City of Albuquerque Stormwater Construction Site Inspection Report

ESC File No.	M10E020	Project Name:	Kidz Academy and The Human Bean		
NPDES Id. No.	NMR1003NO/NMR1003NP	Location:	7800 Sage Rd. SW		
2/28/2022	Owner	Contractor			
Operator	Kidz Academy and Tres Lobos		Creative Design Builders		
Contact name & title	Keith Griego		Raymond Herrera		
e-mail	kidzacademystaff@gmail.com		rhcdb46@yahoo.com		
Contact Phone #	505-681-7812		505-410-9020		
COA Inspector	Doug Hughes		Start/End Time:	4pm	
Construction Phase:	Vertical				
Type of Inspection:	<input type="checkbox"/> Regular	<input type="checkbox"/> Storm Event	<input type="checkbox"/> Past Storm Event >0.25"	<input type="checkbox"/> 311/Complaint	<input checked="" type="checkbox"/> Follow Up
Weather at time of inspection?	clear		Temperature:	~	60
Estimated date of last storm 0.25" or greater	1/1/2022

TEMPORARY EROSION AND SEDIMENT CONTROL PLAN

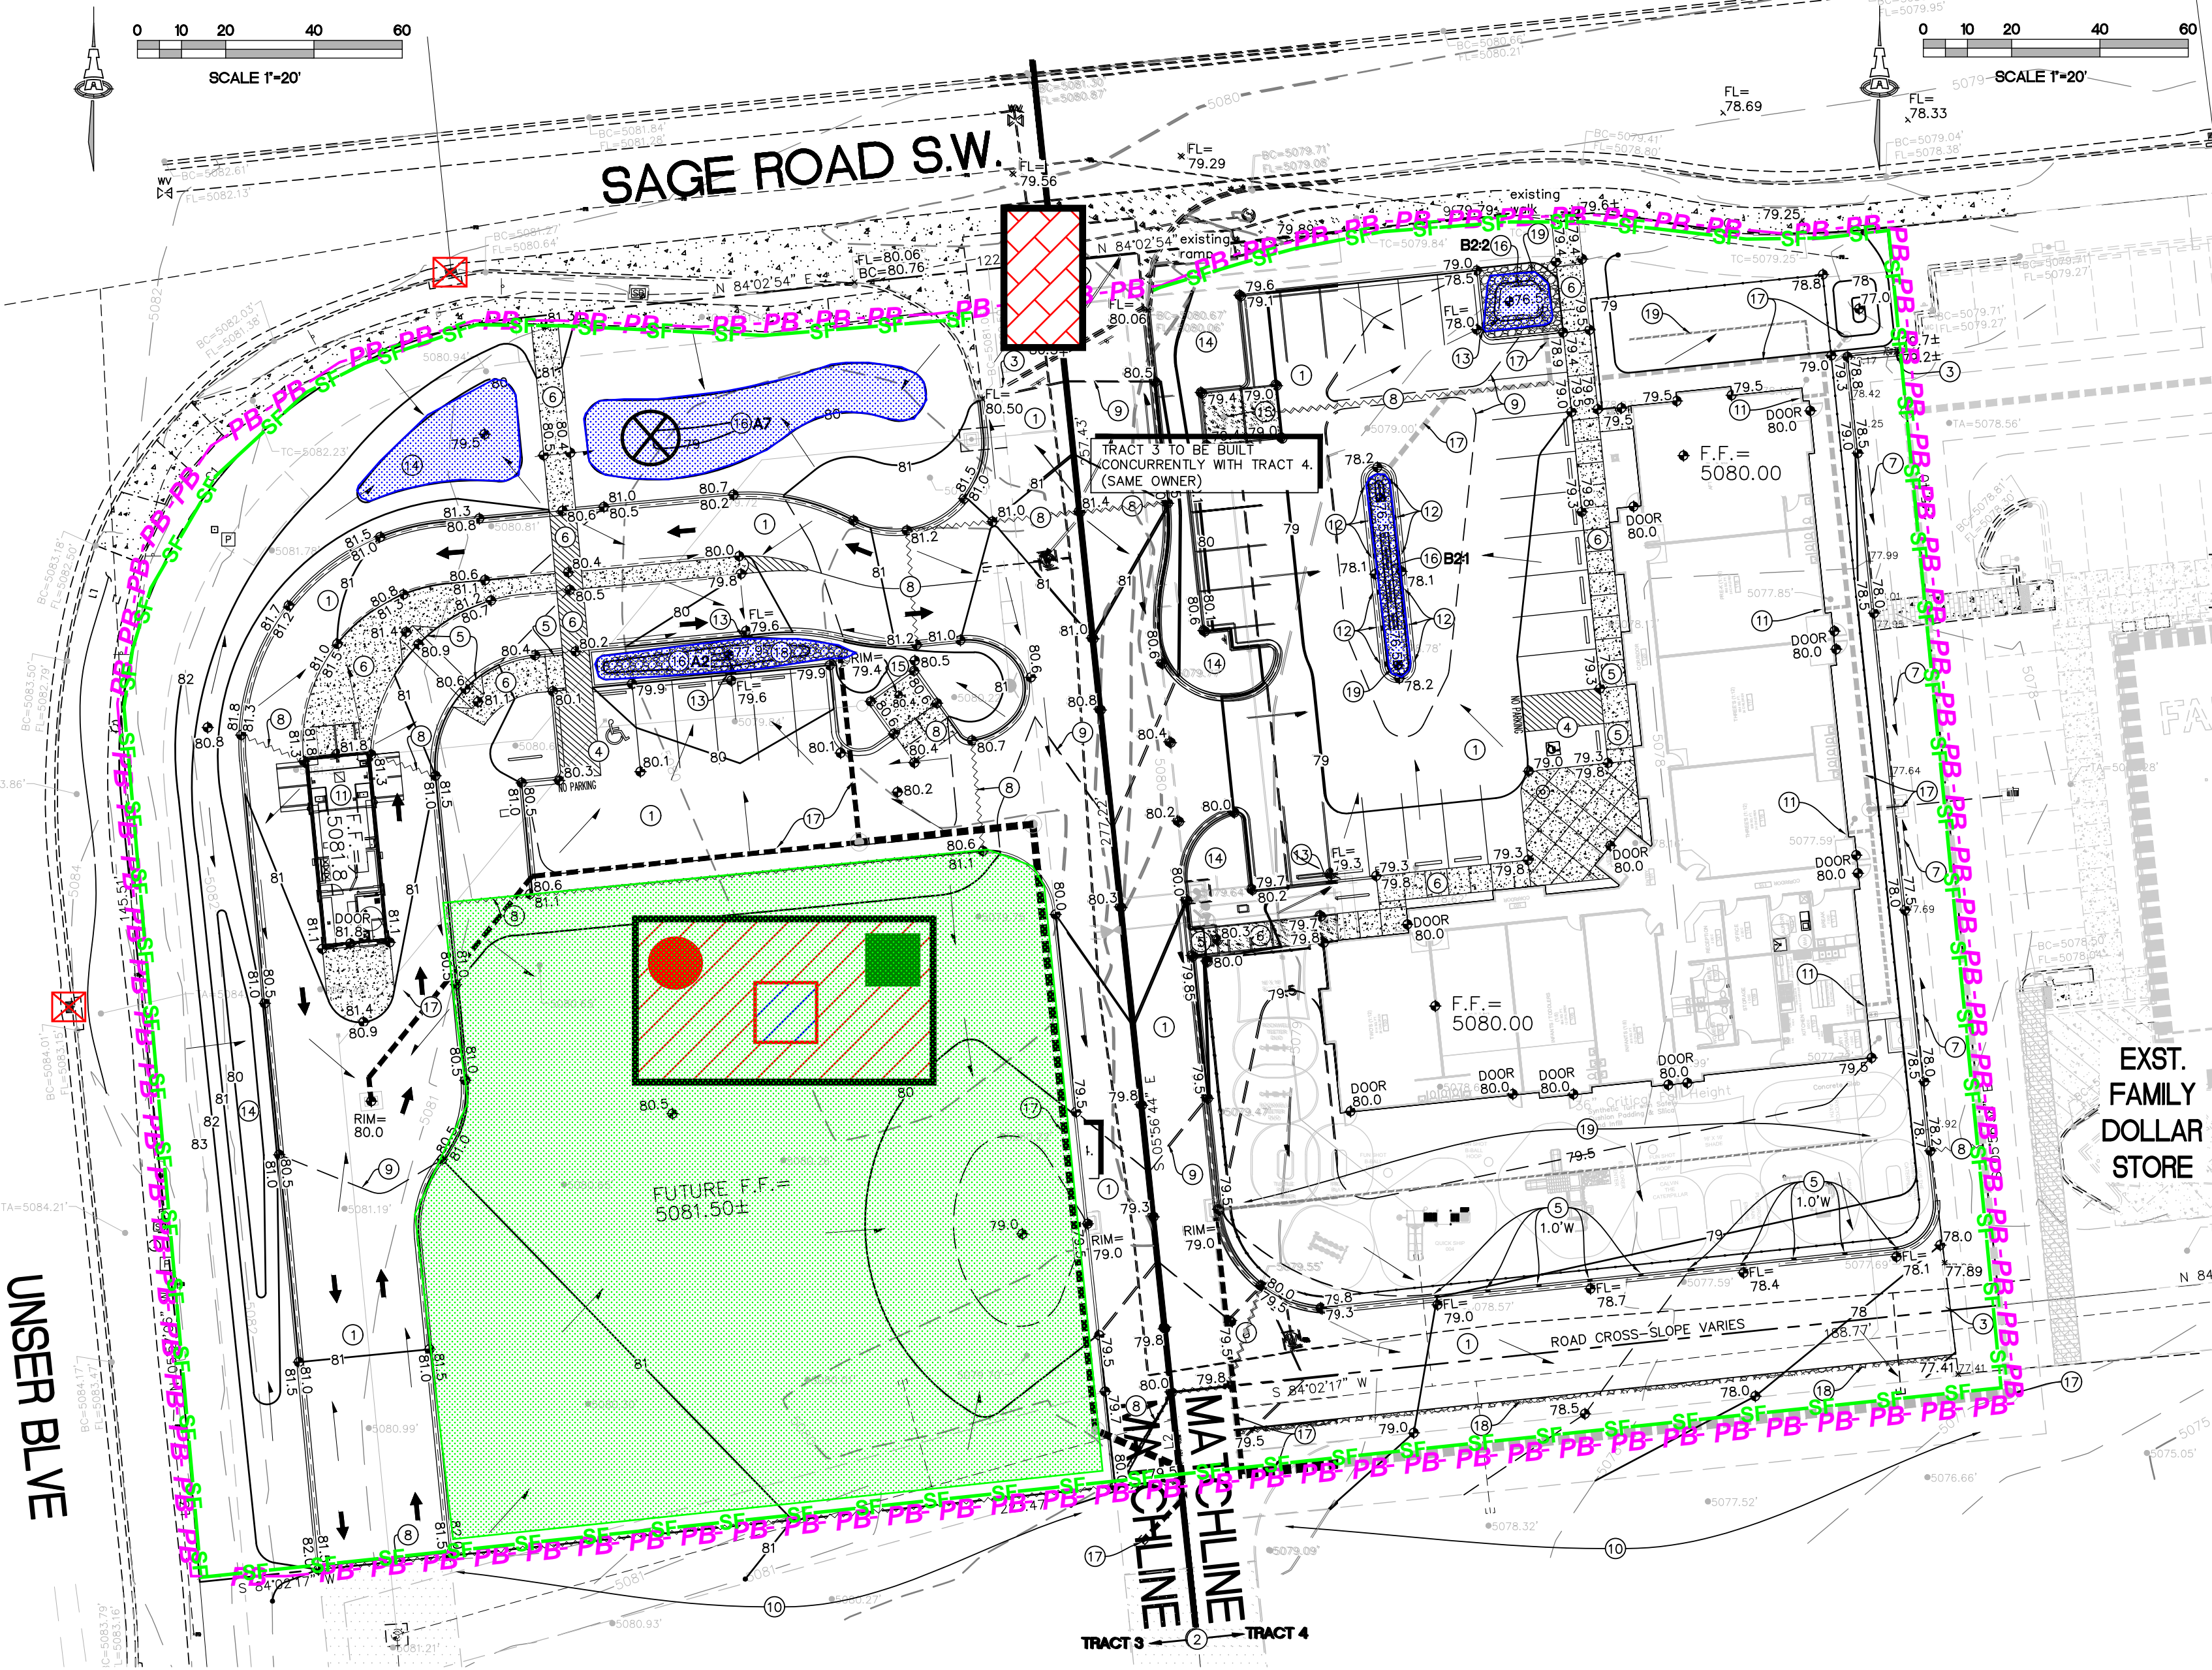
Item Number	Deficiency/ Corrective Action				
1	none				
2					
3	Remember, Cover (SEED AND Mulch) is required in all areas to remain inactive for 14 days or more including dirt between buildings onsite, street frontage, and new disturbance south of south driveway.				
4
